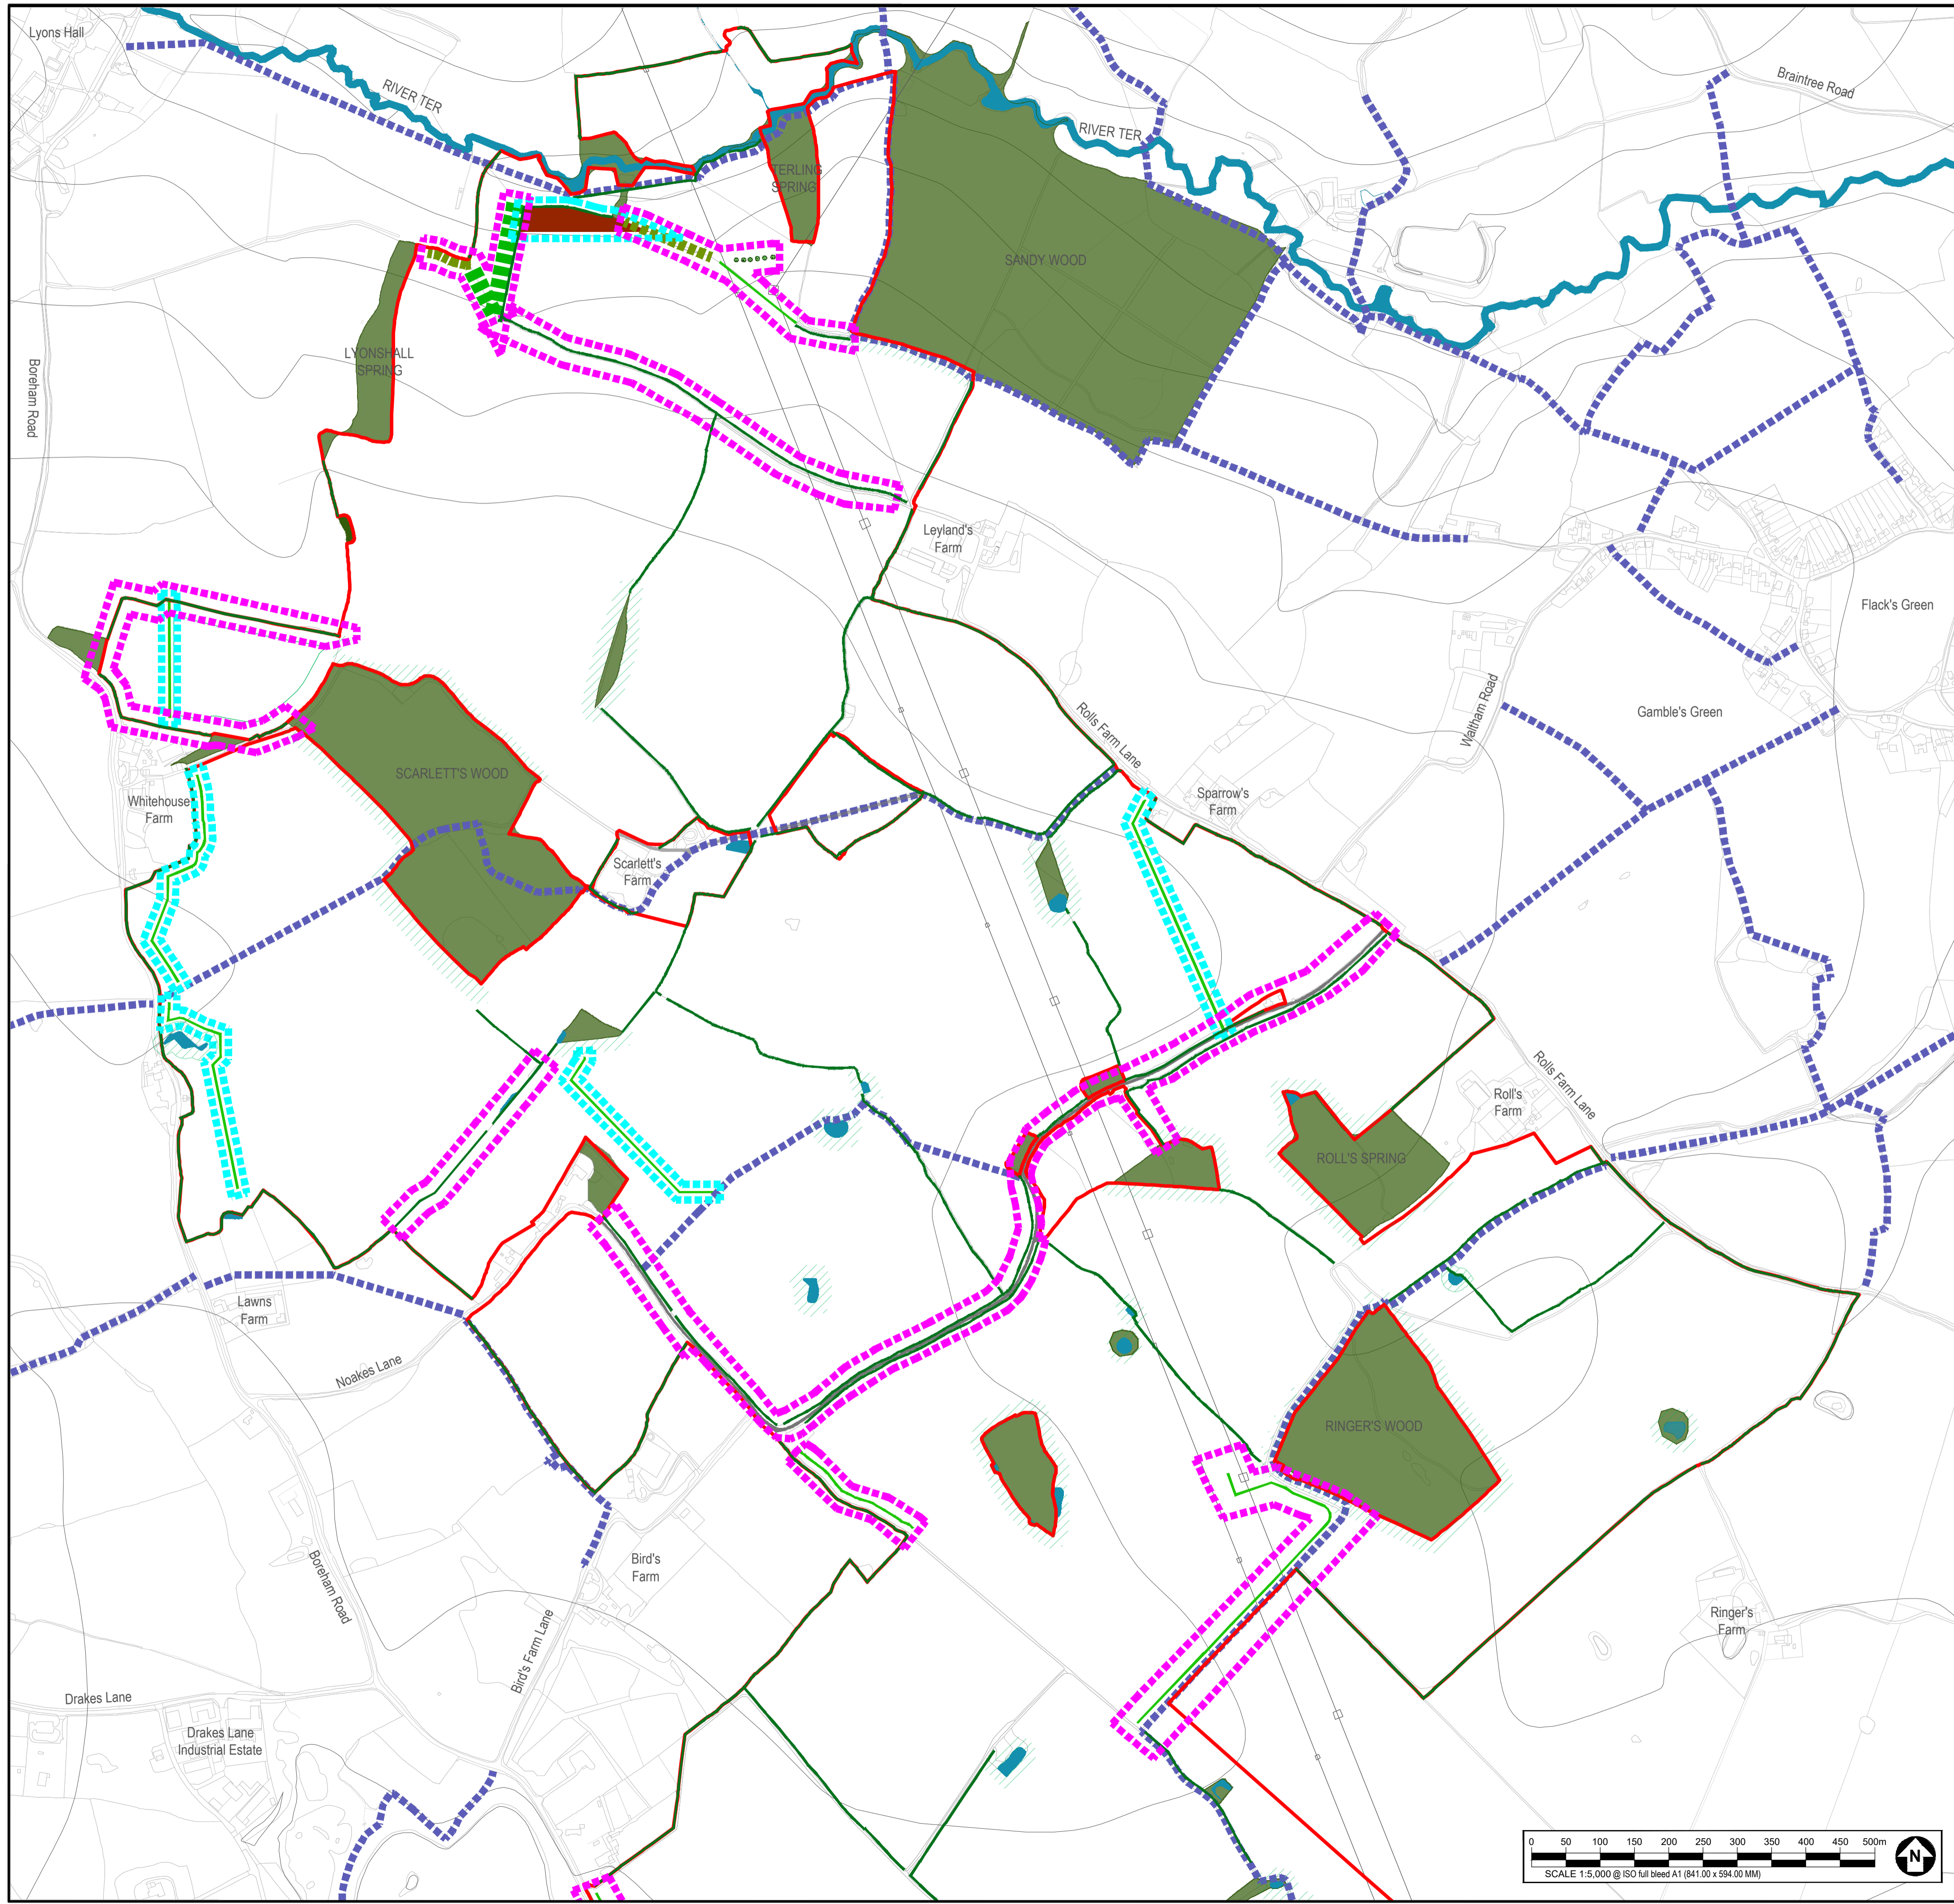
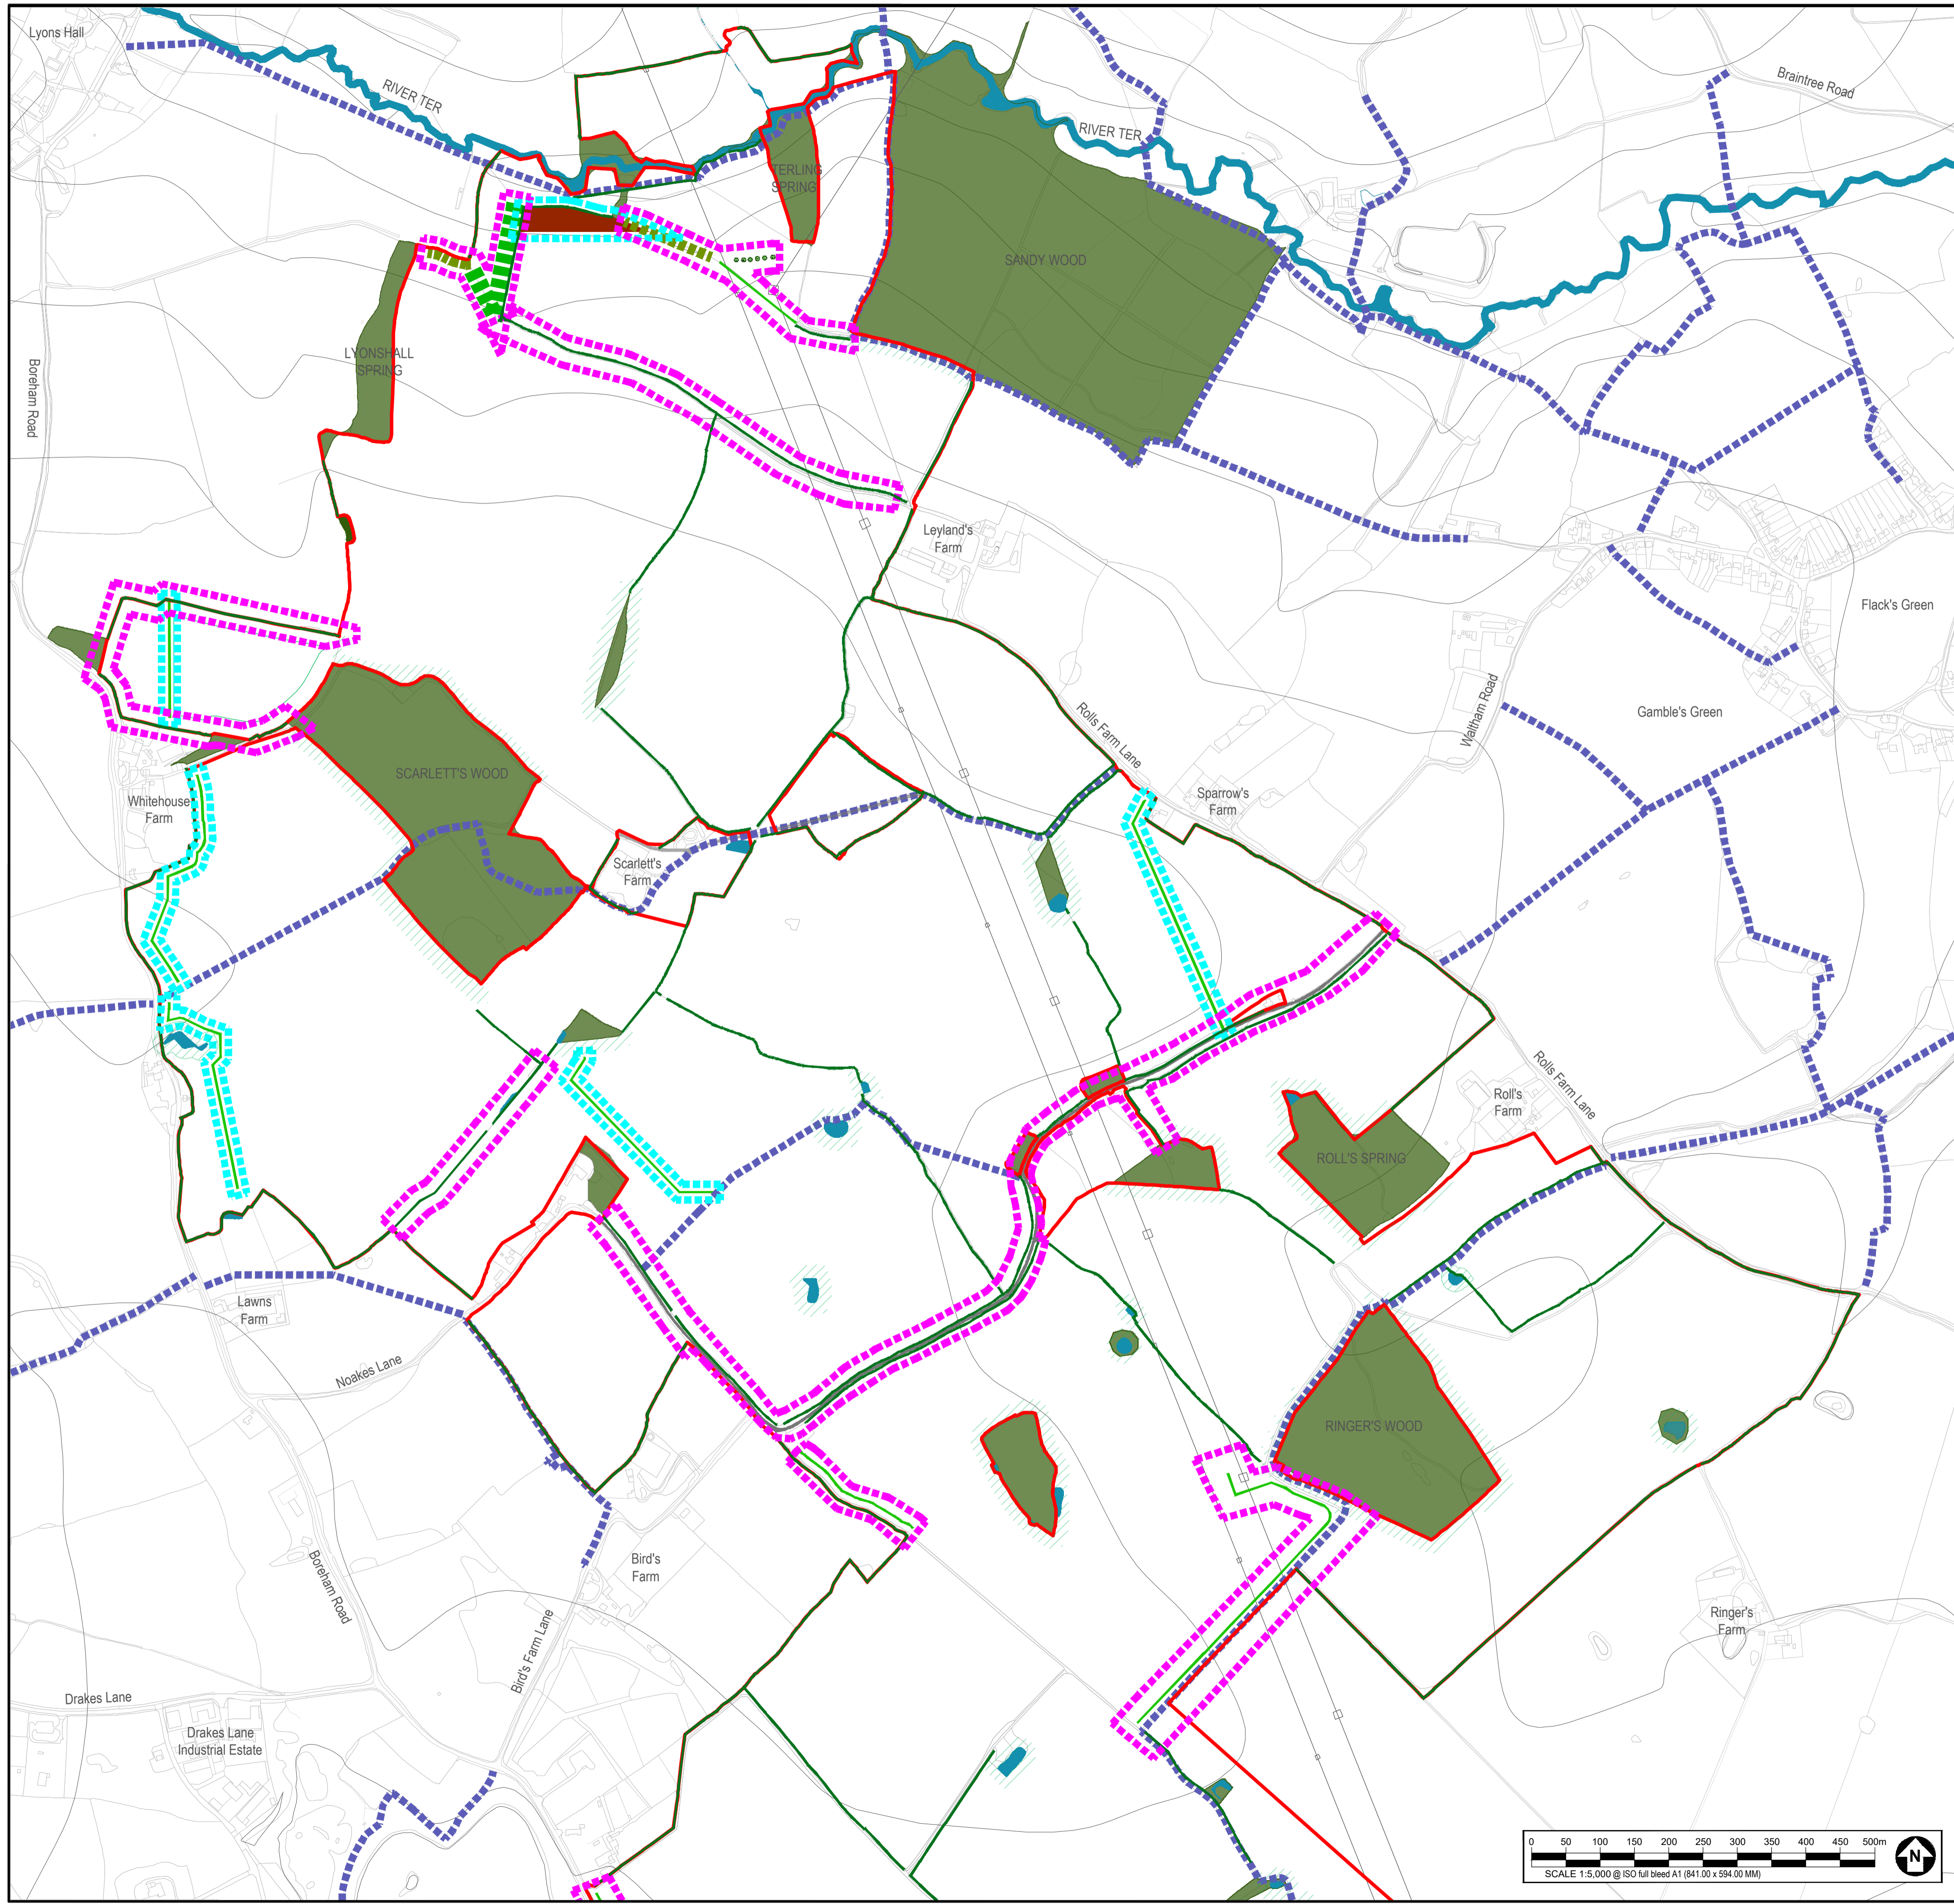
EBA has previously made representations that the proposed north to south green route via a new permissive path should be available to all user groups (including horse riders) and not just pedestrians and cyclists. The Applicant responded to this representation via Document reference EN010118/EX/8.1 with the following response 'There are no designated bridleways that the permissive path could connect to and therefore the Applicant is not seeking its designation as a bridleway. The permissive paths will be designed for pedestrians and cyclists'.

However, there are public roads closer to and through the site that can be used by WCH users now (walkers cyclists horse-riders) and to which any new permissive path will naturally link. EBA continues to consider therefore that the new permissive path (s) should be accessible to all, and is disappointed that the Applicant appears unwilling to improve accessibility for horse riders, which would be both straight forward and equitable. Given that the permissive path (s) will link to public roads that horse riders can currently use, we request that the Applicant reconsiders its response.
